From: Kathryn Griffiths [REDACTED]
Sent: 20 February 2019 15:44
To: Simon Davis
Cc: Zoe Knott
Subject: RE: Burndell Road - Y/98/18/RES

- Street lighting (SSE235781 Letter of approval)
- Layout (18-1065-005 C Site Plan Planning Layout)
- Affordable housing tenure mix layout (18-1065-005 C Site Plan Planning Layout)
- Soft Landscape Proposals (BOV22172 – 11E sheets 1-5)
- Hard Landscape Proposals (BOV22172 – 12E sheets 1-5)

BOVIS HOMES
scheme: Land off Burndell Road Yapton
client: Bovis Homes
drawing: Hard Landscape Proposals
date: Nov. 2018
scale: 1:200@A1
drawing no: BOV22172 12E sheet 4
drawn: AE checked: DKM

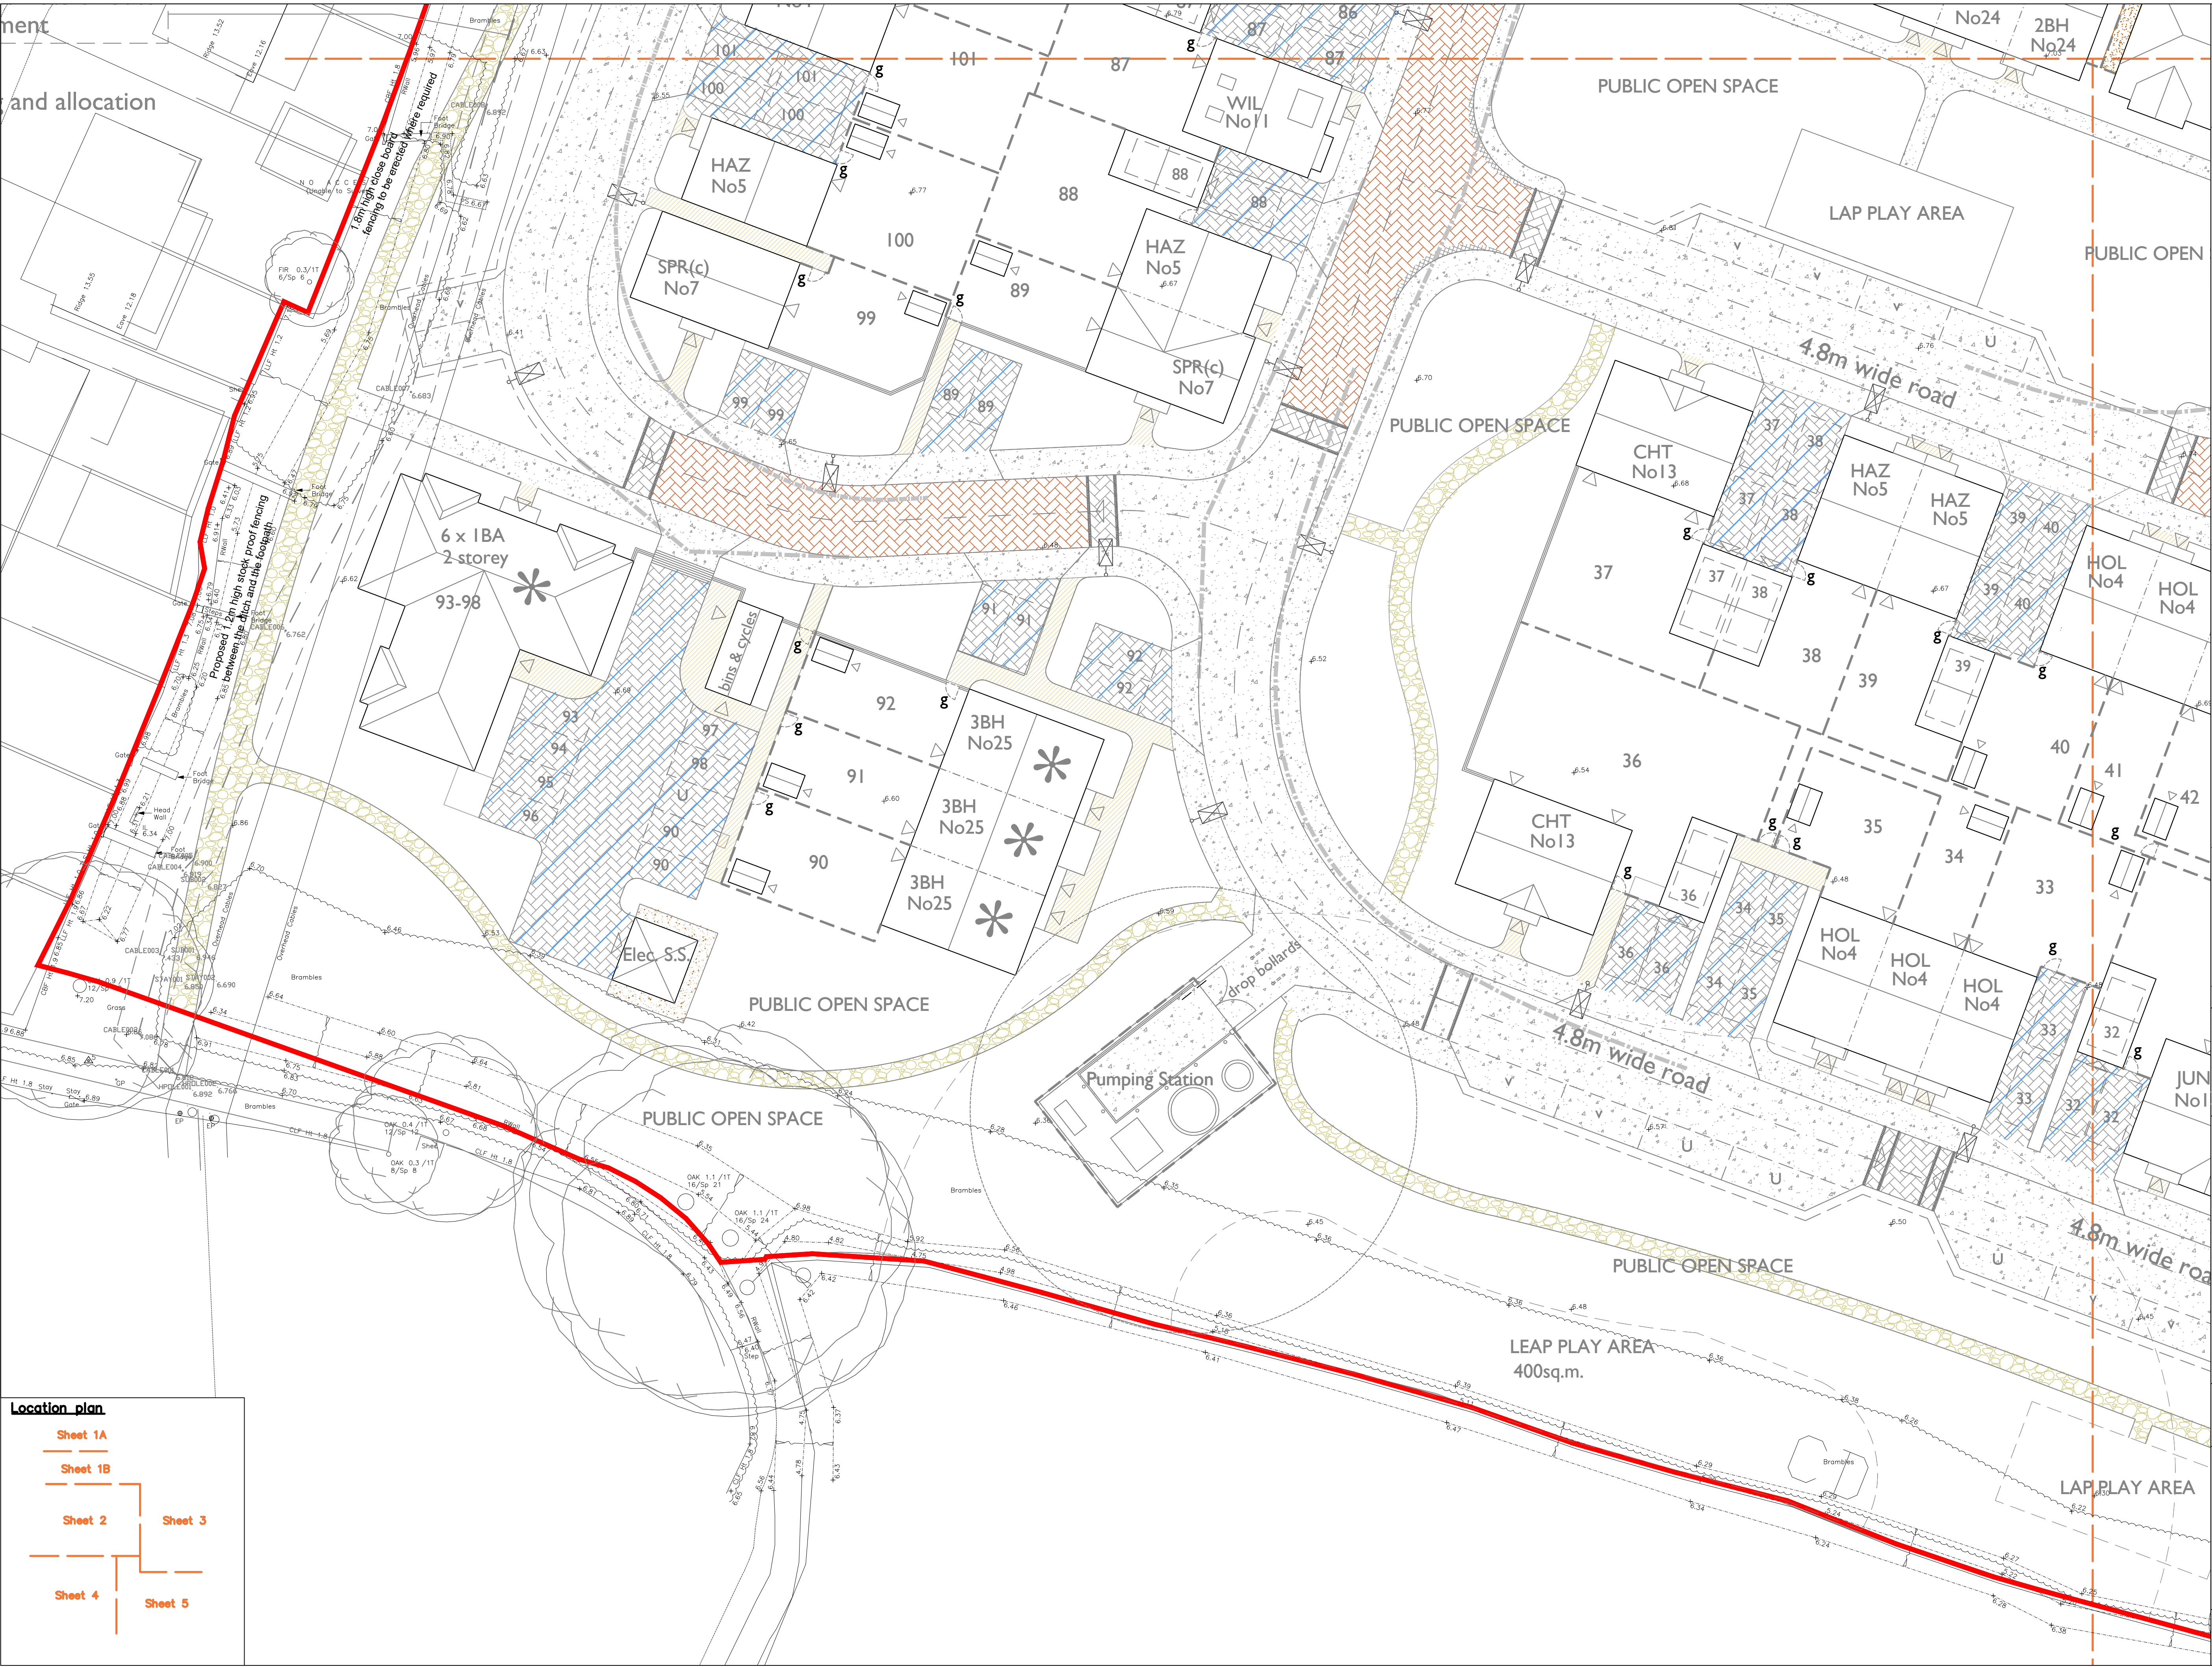
- (5) As you are aware concerns remain re the relationship of existing trees to the attenuation pond (I await Tree Officer comments on this).

The landscape plans have been updated to accord with the latest layout plan and drainage comments received on 2nd and 4th January 2019. Soft landscape drawing (BOV22172 11 sheet 4) shows that trees located immediately south of the attenuation pond and two *Alnus Glutinosa* trees to the south of the electricity substation have been removed to provide sufficient easement (5m buffer) from the attenuation features and watercourses. Soft landscape drawing (BOV22172 11 sheet 4) also shows trees alongside the pump station to have been removed/relocated and hedges have been adjusted in line with the sight lines.

The relationship between the existing trees to the attenuation ponds has been reviewed and the trees are now away from the bank of the watercourse as shown on the revised landscaping plans.

drawing no: BOV22172 11L sheet 5

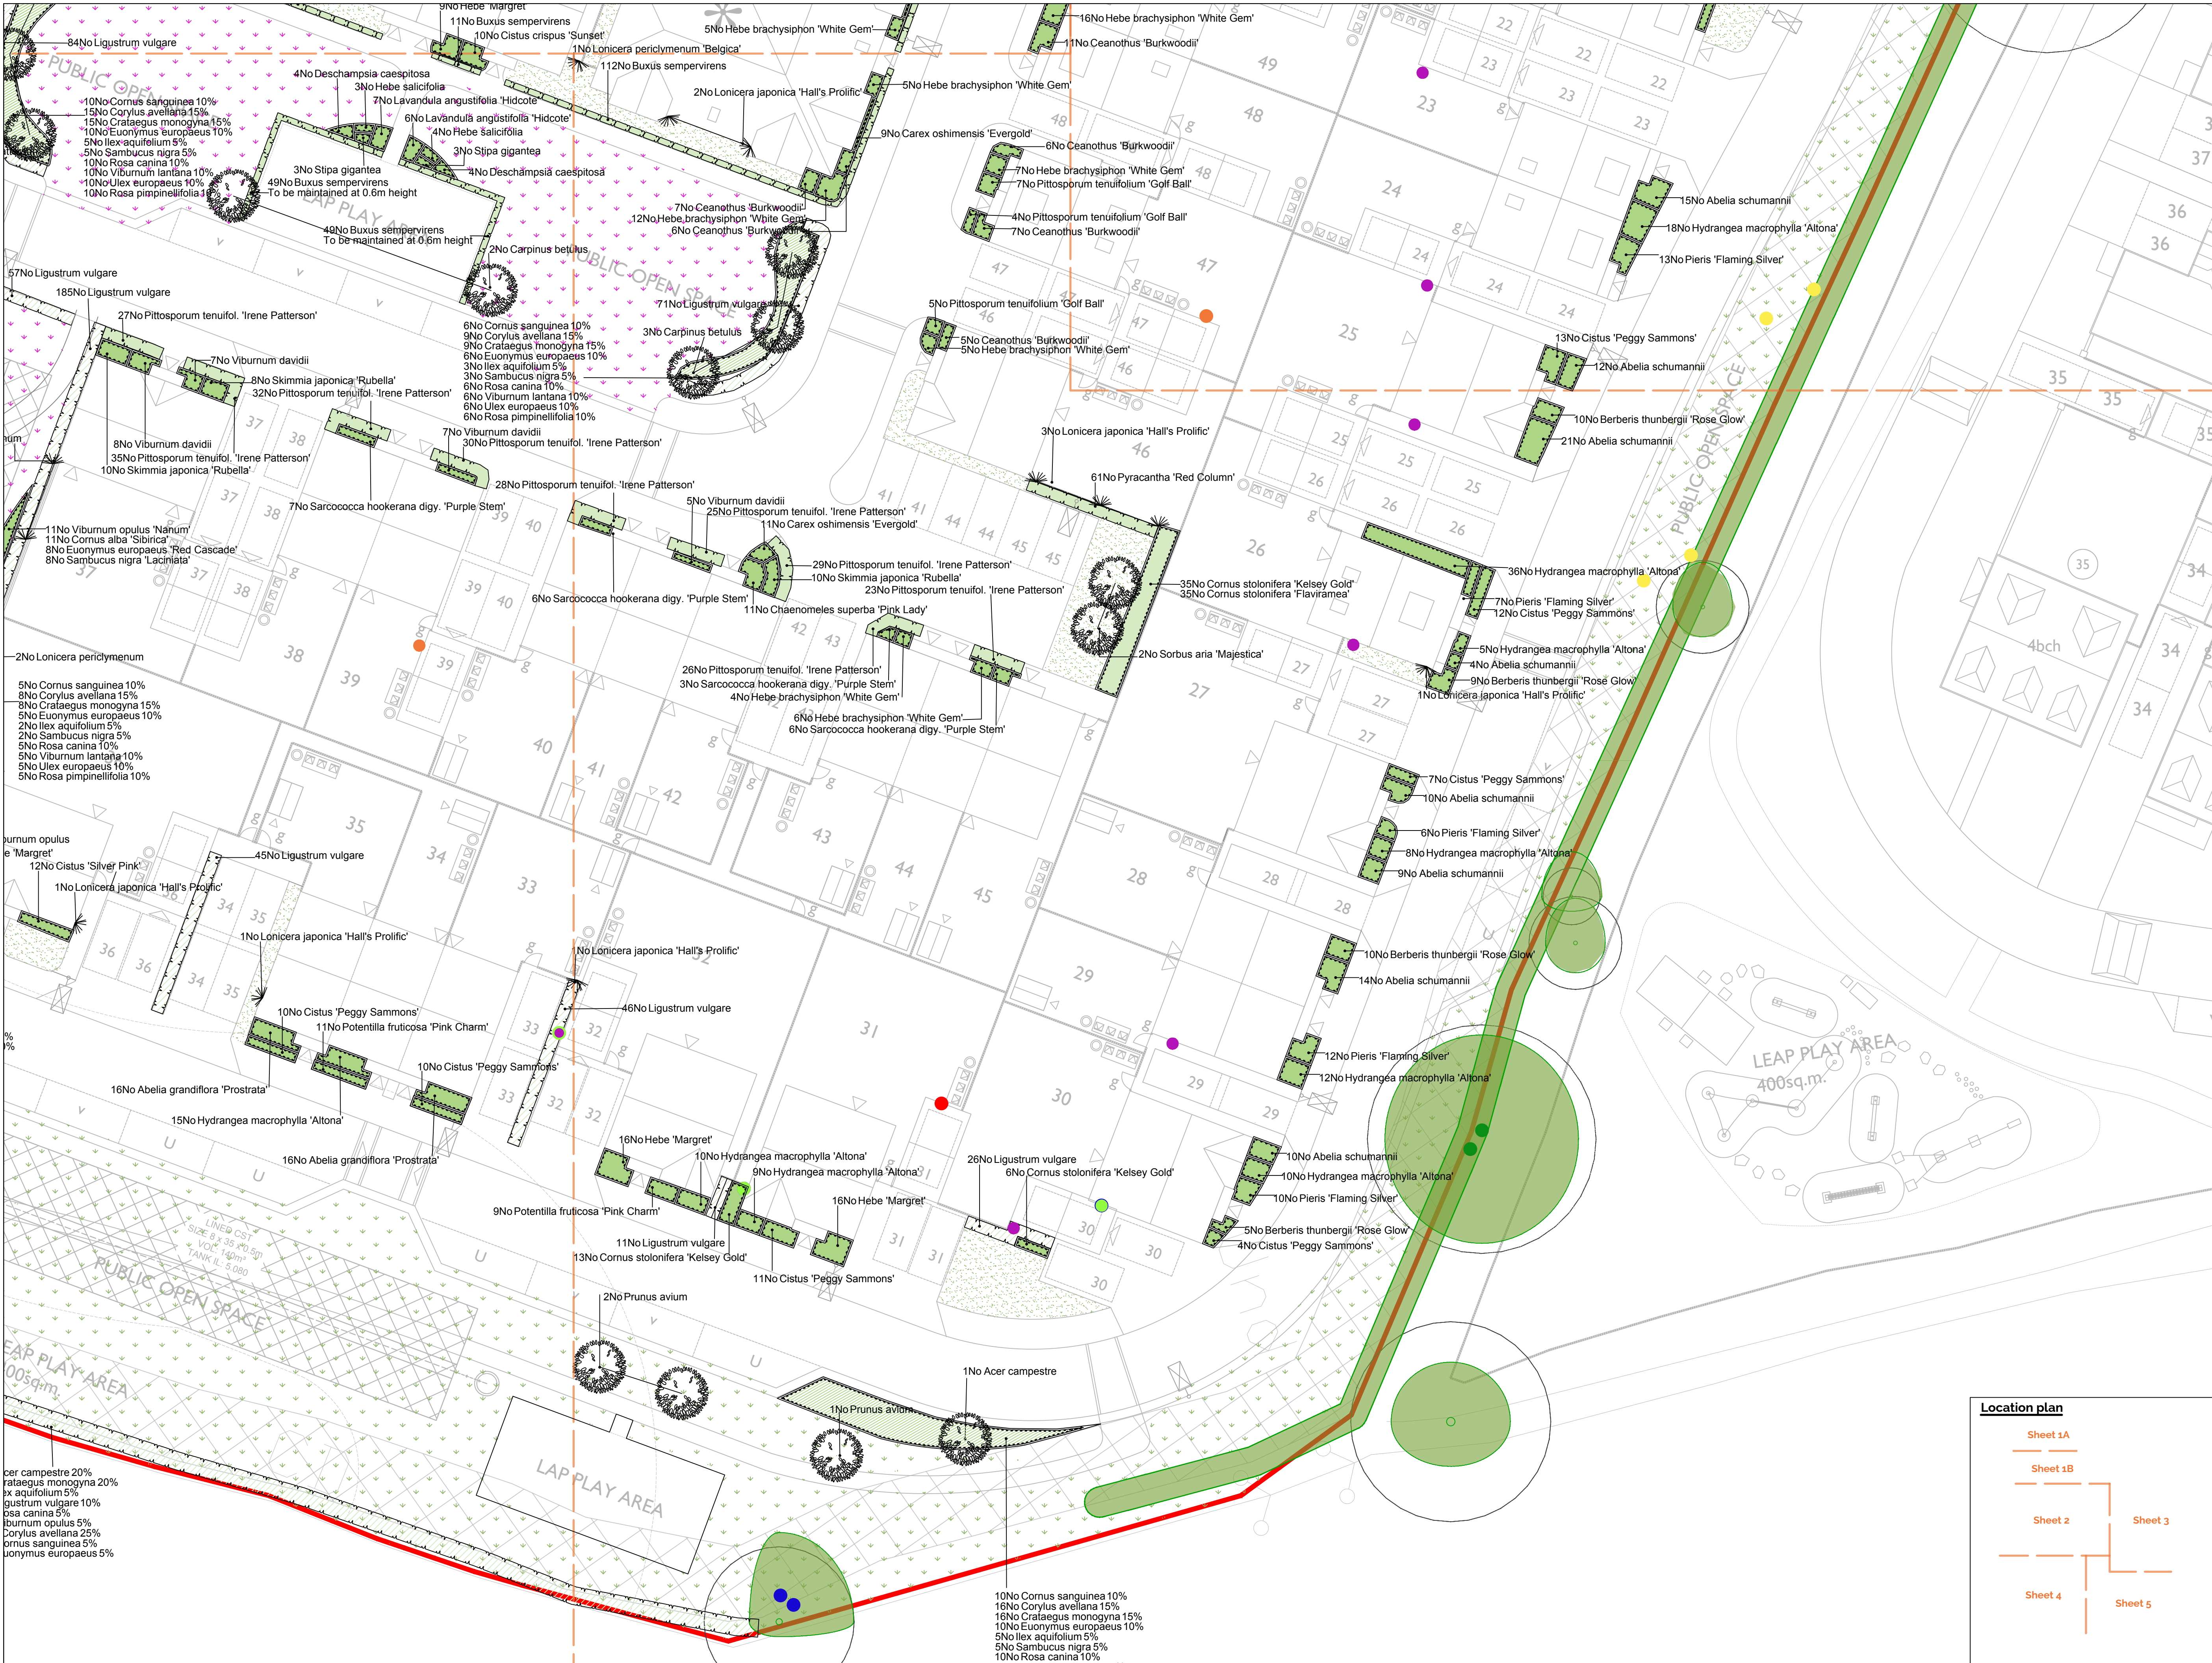
- (2) There needs to be some kind of link into the adjoining site at the SE corner. I note your points on this matter but can you at least just not include a boundary here so people can walk across grass between the two sites. I note that the indicative layout provided at outline was amended from that submitted at pre-application to create a shared greenspace, fronted by dwellings from both developments with scope for pedestrian and possible vehicular links between the two layouts in addition to the shared greenspace between the developments;

We take on board your point to not include a boundary to the south east corner and this can be shown on soft landscape drawing BOV22172-11E sheet 5..
